Martin Nugent
01254 828060
D3/12/0986

Drafted 28 November 2012

**Planning Application, Ribble Valley District
3/12/0986 Former garage, Branch Road, Waddington**

PROPOSED PLANS, ELEVATIONS, & SECTION A-A	
Site: Conversion from a garage to a bungalow The Garage, Branch Road Waddington Lancashire	
Client: Mr Colin Taylor	
Date: 22 08 12	Scale: 1:100 @ A2
Project No: TAYLO/02 Dwg 02	Drawn: ML / NYB
Amendments:

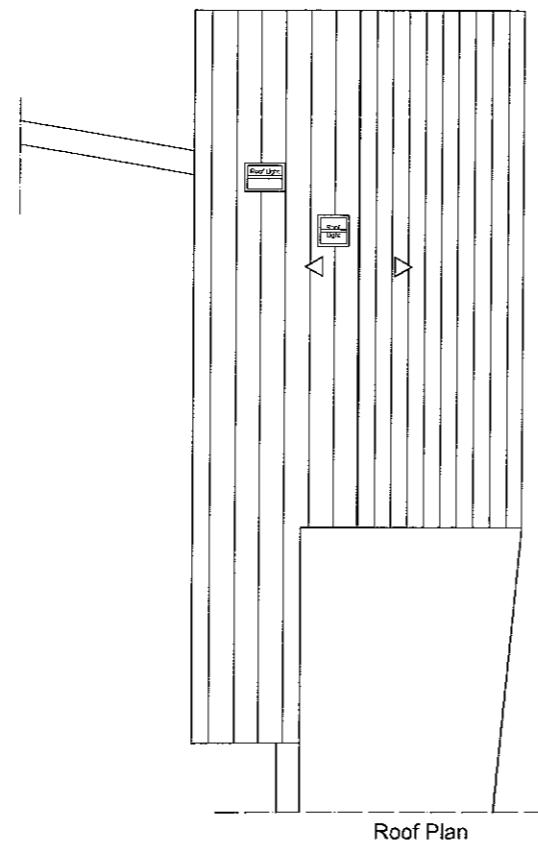
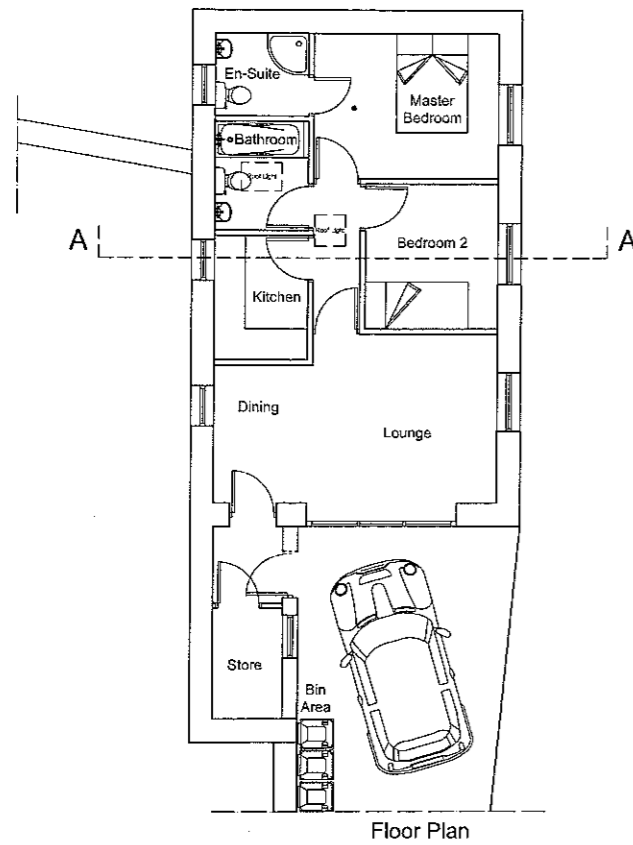
While the car parking space provided is adequate to house a private saloon vehicle, I have noted that the parking plot is slightly elevated from Branch Road (between 0.3 and 0.1m along its length) and that this area must be approached in a precise manner in order to be positioned securely. Similarly, when leaving the space this must be negotiated with care.

However, the space is very conspicuous to other motorists and pedestrians and the space can be utilized effectively and safely without detriment to other road users.
